Application Reference: 2025/0671

Site Address: 30 Chatsworth Road, Athersley South, Barnsley, S71 3QH

Introduction: Erection of rear single storey extension to dwelling

Drawing Title
PROPOSED PLANS

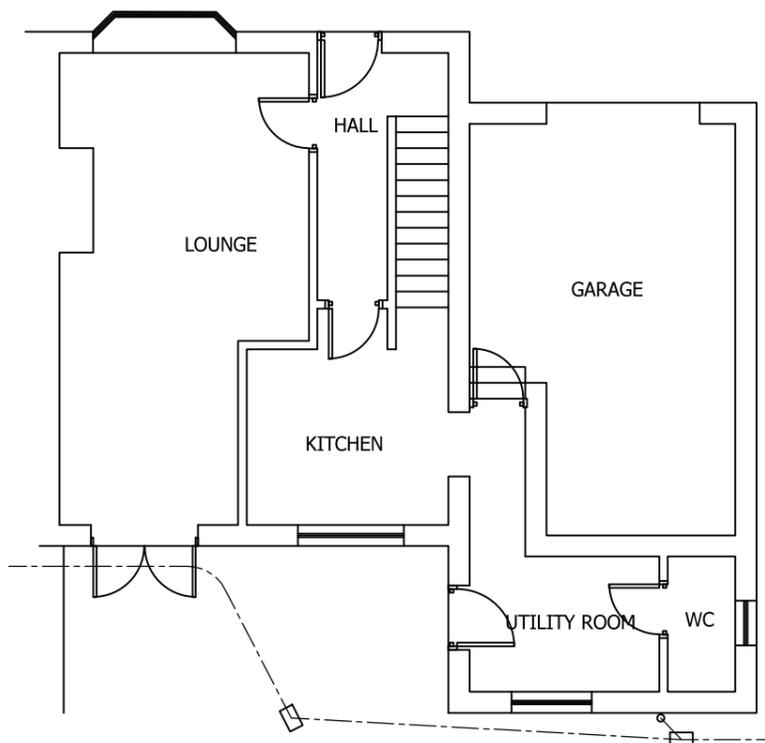
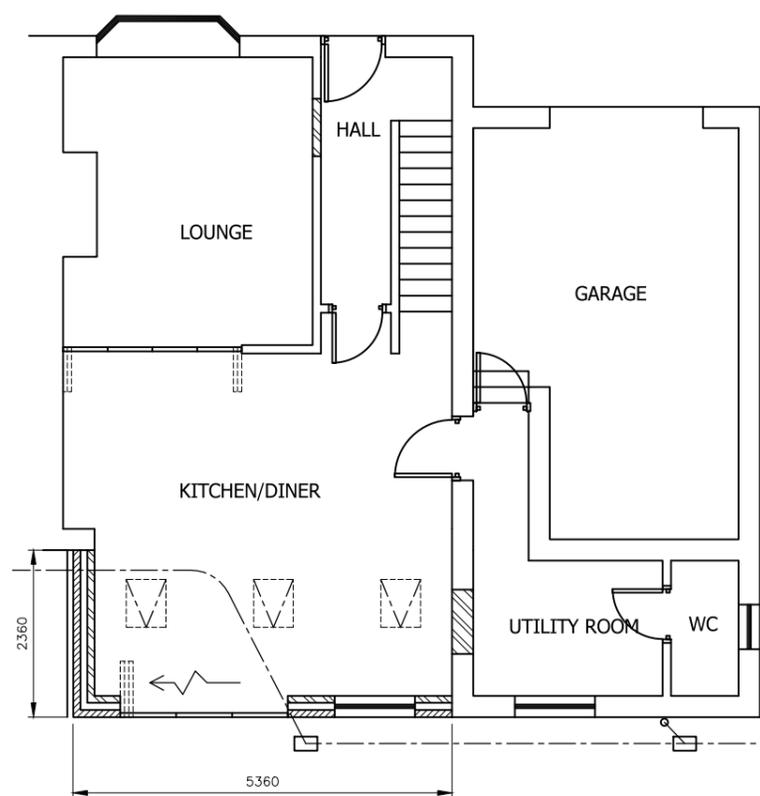
The proposed rear extension provides a rearward projection of approximately 2.4 metres which is considered acceptable in reference to the House Extension SPD. An eaves height of approximately 2.4 metres is also detailed which is in line with the House Extensions SPD. The use of a lean to roof form is preferred, despite not being seen from the highway. The proposed rear bifold doors are detailed sympathetically to the dwelling and the use of matching materials is welcomed.

Drawing Title **PROPOSED ELEVATIONS**

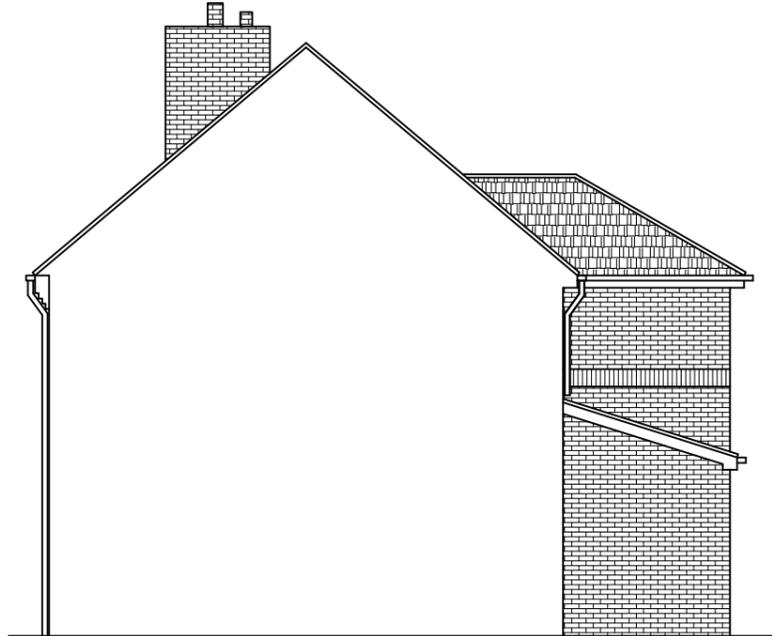
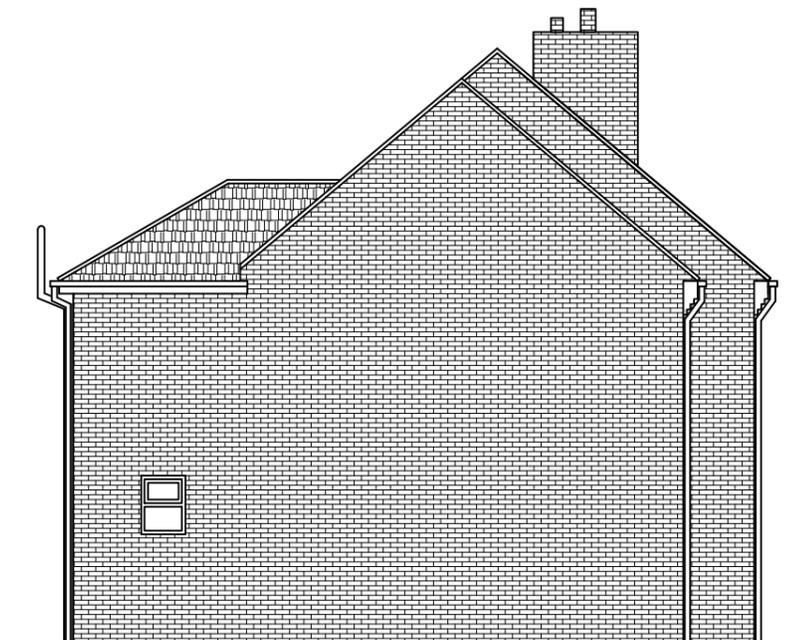
Given the proposed extension would be erected to the North of adjoined 28 Chatsworth Road, the proposed extension would provide little to no loss of sunlight. The proposal is a modest size and provides limited to no loss of sunlight or outlook to neighbours. The use of a lean to roof assists in reducing the impact of the proposal nearest to neighbours. In terms of overlooking, there is only glazing on the rear elevation looking into the applicant's garden. Substantial boundary treatment also assists in screening the proposal which both reduces the impact of the proposal and prevents opportunity for overlooking.
